LEES 1 Science Research and Teaching Facility (SSD 7054) and F23 Administration Building (SSD 7055), The University of Sydney.

Katrina Stankowski
Acting Manager, Conservation
Heritage Division
Office of Environment & Heritage
As Delegate of the Heritage Council of NSW
26/07/2016

HERITAGE COUNCIL OF NSW COMMENTS (dated 26 August 2015)

Figure 5.4 Proposed development footprint for Administration Building (F23) and the new Carlsaw Extension. (F07) (Source: University of Sydney 2015).

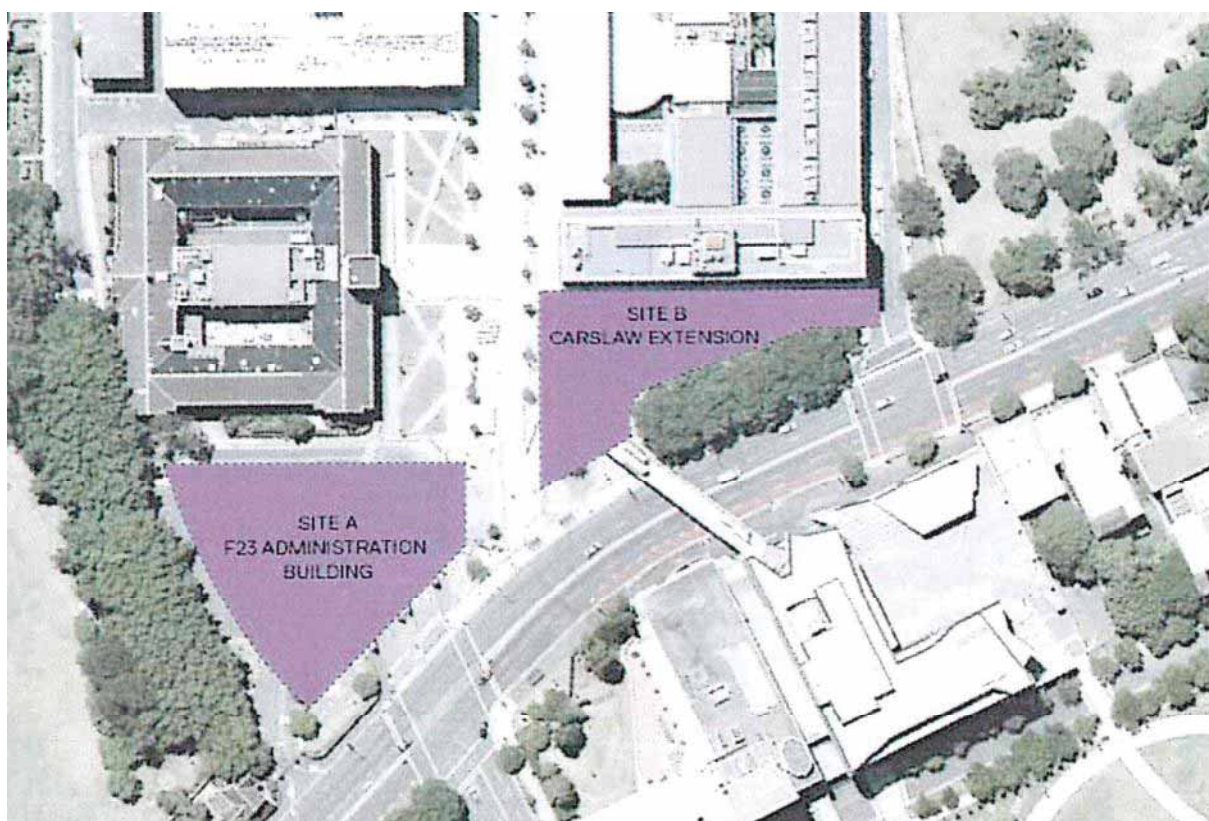
The Heritage Council recommends that the University of Sydney submit revised architectural drawings for assessment. The eastern façade should be setback a minimum of 4 meters to respect the alignment of the Marsden and Anderson Stuart Buildings, and provide more open landscape (public domain) at the southeast corner of the proposed building at City Road.

Plate 7: Showings Tree 970-971

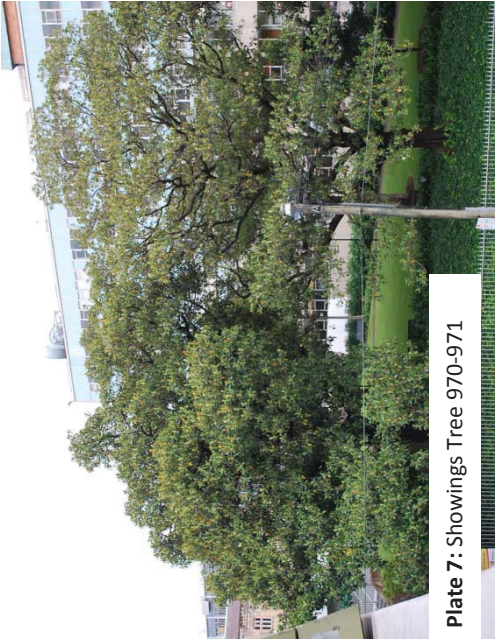
the canopy and Tree Protection Zone of the four (4) Moreton Bay Figs would have a significant adverse heritage impact on the identified state heritage values of *The University of Sydney and Victoria Park as connected landscapes*. The trees date from the 1880s when this portion of land was part of Victoria Park and are graded Exceptional and High significance in the Grounds CMP.

The Heritage Council recommends that the University of Sydney submit revised architectural design drawings for assessment. The southern façade (levels 1-4) and overhanging stepped façade (levels 5-8) should be setback a further 3 metres from these Morten Bay Figs; to ensure that the LEES1 Building development does not encroach into the canopy and Tree Protection Zone of the four (4) Moreton Bay Figs along City Road, numbered T970, T971, T972 and T973 in the Arborist Report.
